**PROJECT APPLICATION MP_08_0093 - RESPONSE TO ISSUES
DARLING WALK, DARLING HARBOUR**

Following the exhibition of the Project Application MP_08_0093 for Public Domain Works at Darling Walk, Darling Harbour, on behalf of Lend Lease Development, JBA Urban Planning Consultants has prepared this response to respond to the issues raised during the public consultation, describe the proposed revisions to the development and provide a revised Statement of Commitments.

Retail signage zones

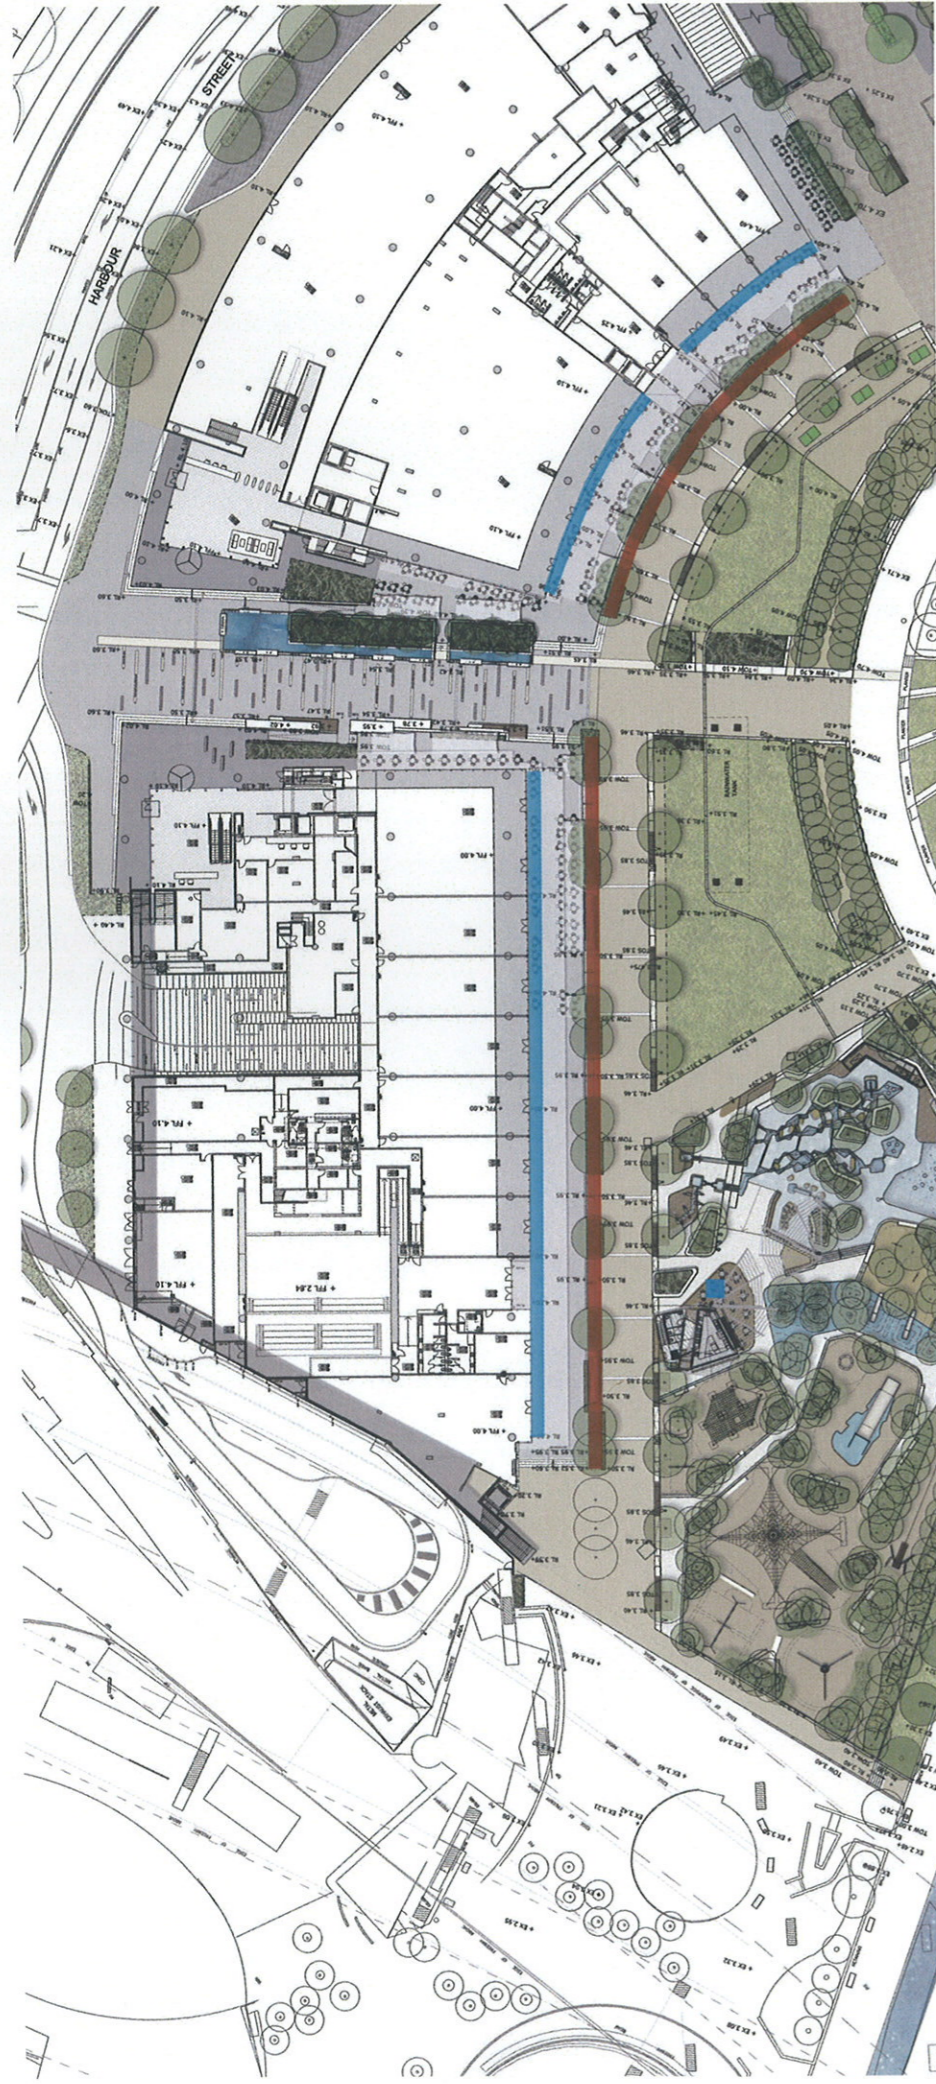
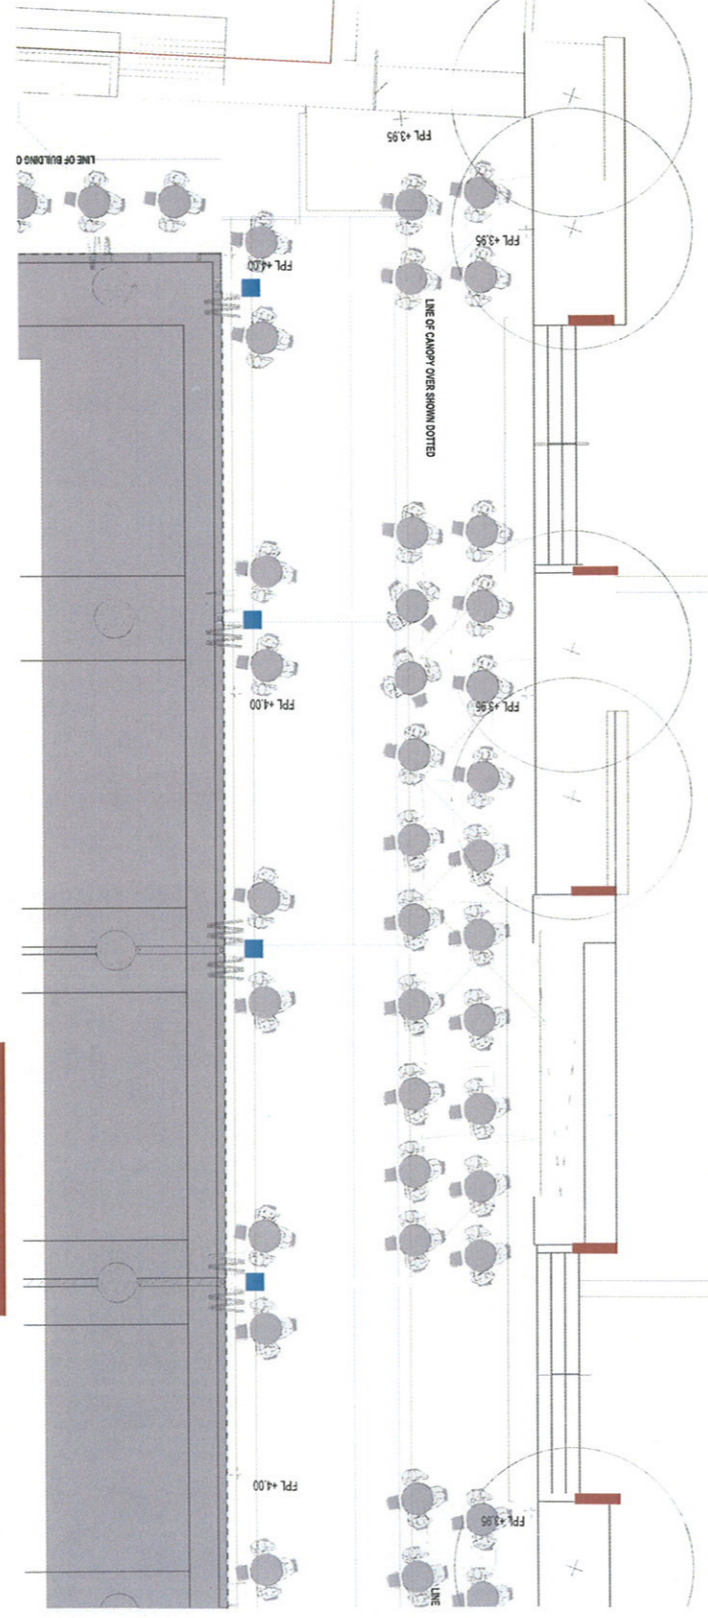
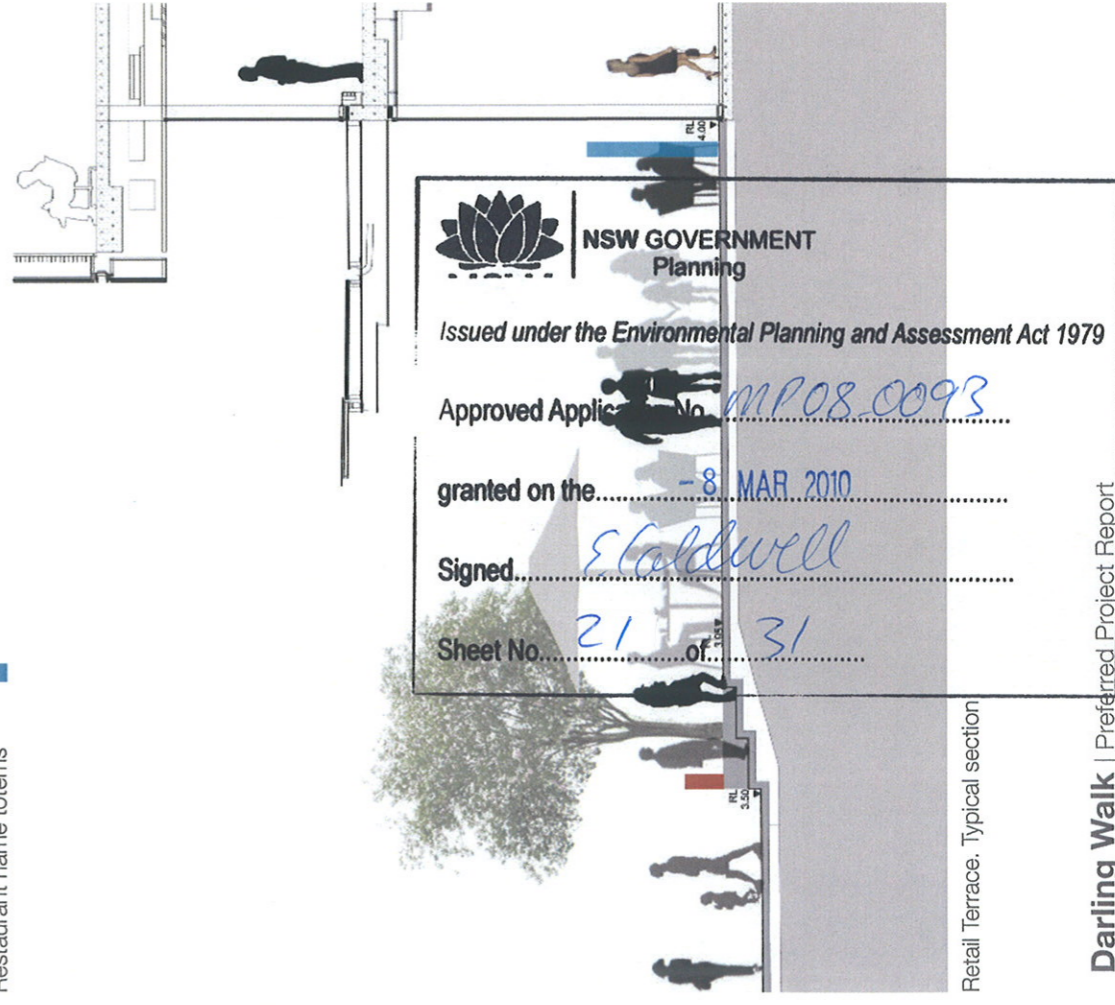
Lend Lease Development seeks a minor amendment to the Project Application to allow the provision of menu display boards and tenant totems along the Retail Promenade. It is proposed that the totems will identify the retail tenants names, the Children's Theatre and Car Park Entrance Lobby. The proposed menu display boards and tenant totems are similar to those provided along Cockle Bay Wharf and elsewhere within the Darling Harbour precinct, as shown in the revised Landscape Drawings at **Attachment A**.

Approval for the menu boards and totems is being sought as part of the application to ensure uniformity in design and size of structures in the Darling Walk precinct. One menu board per tenancy is proposed, and they are to be located at the entrance to the outdoor seating areas on the retail promenade. The proposed Menu Boards are consistent with the Sydney Harbour Foreshore Authority's Commercial Signage Policy.

AMENITIES KIOSK

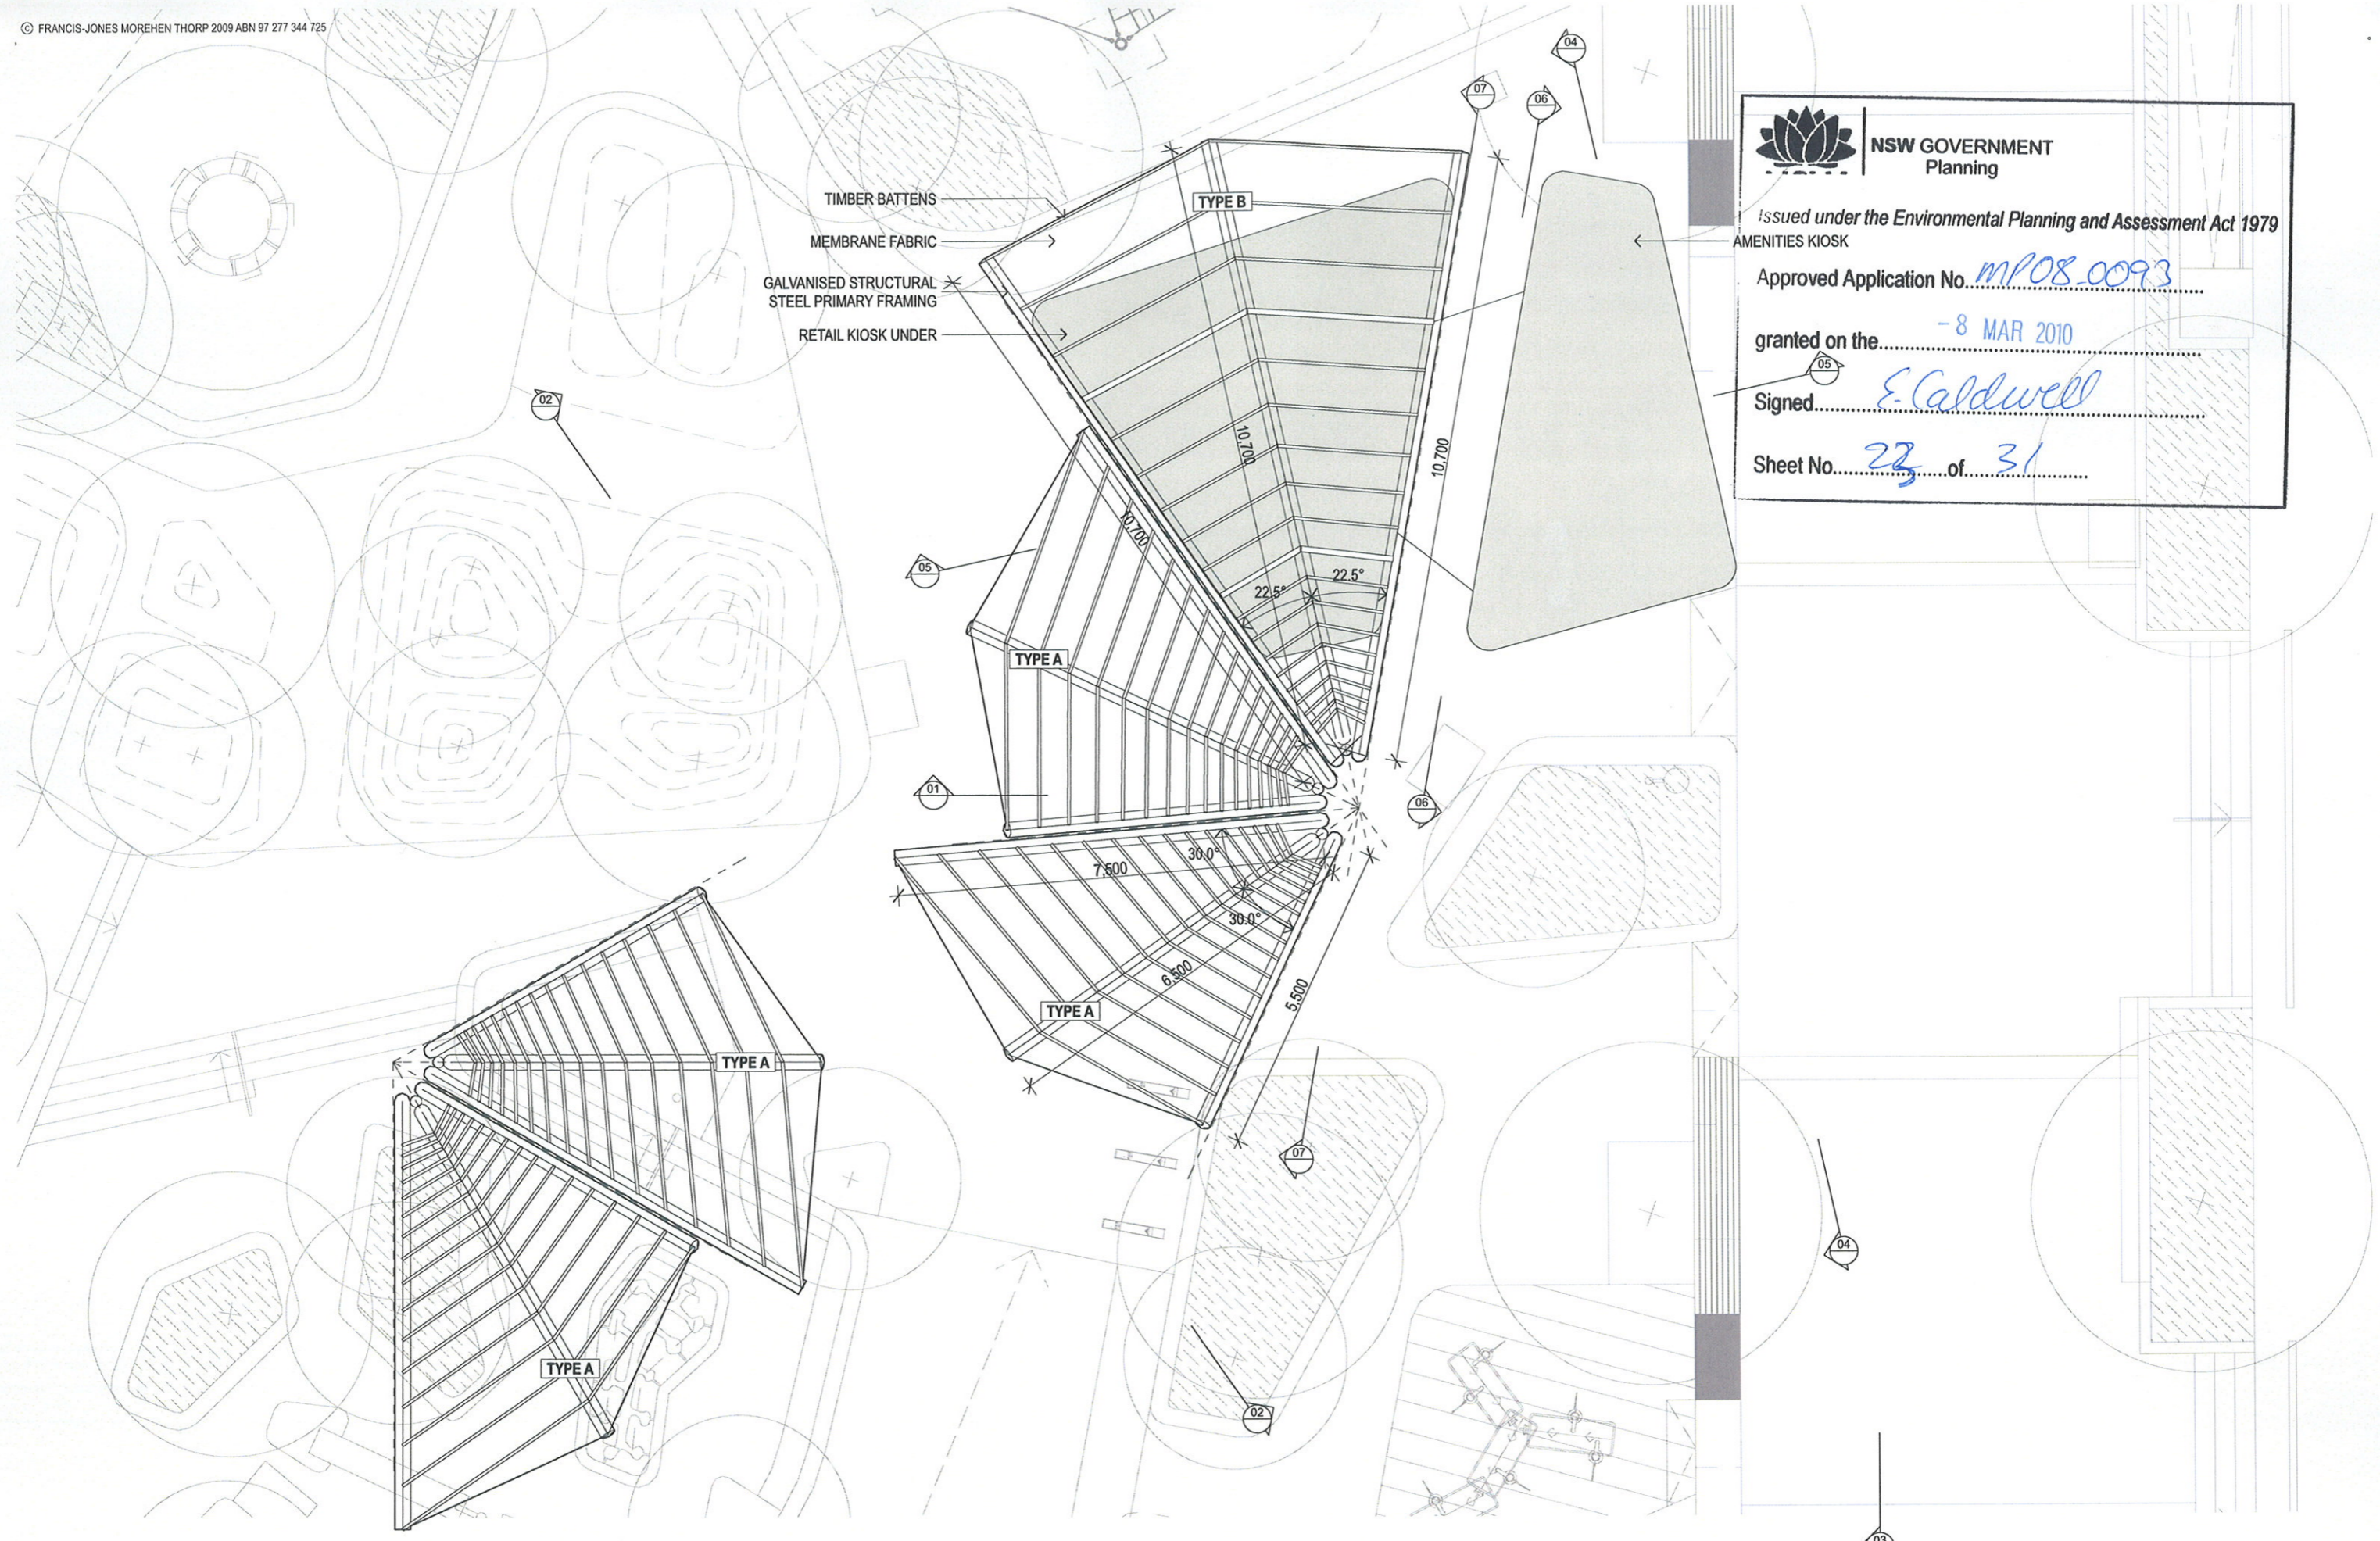
Lend Lease Development seeks approval for a tenant signage zone on the side of the kiosk as shown on the plans at **Attachment B**. The design of the signage will be related to the future tenant use, will sit within the approved signage zone and will be in accordance with the Sydney Harbour Foreshore Authority's Commercial Signage Policy.
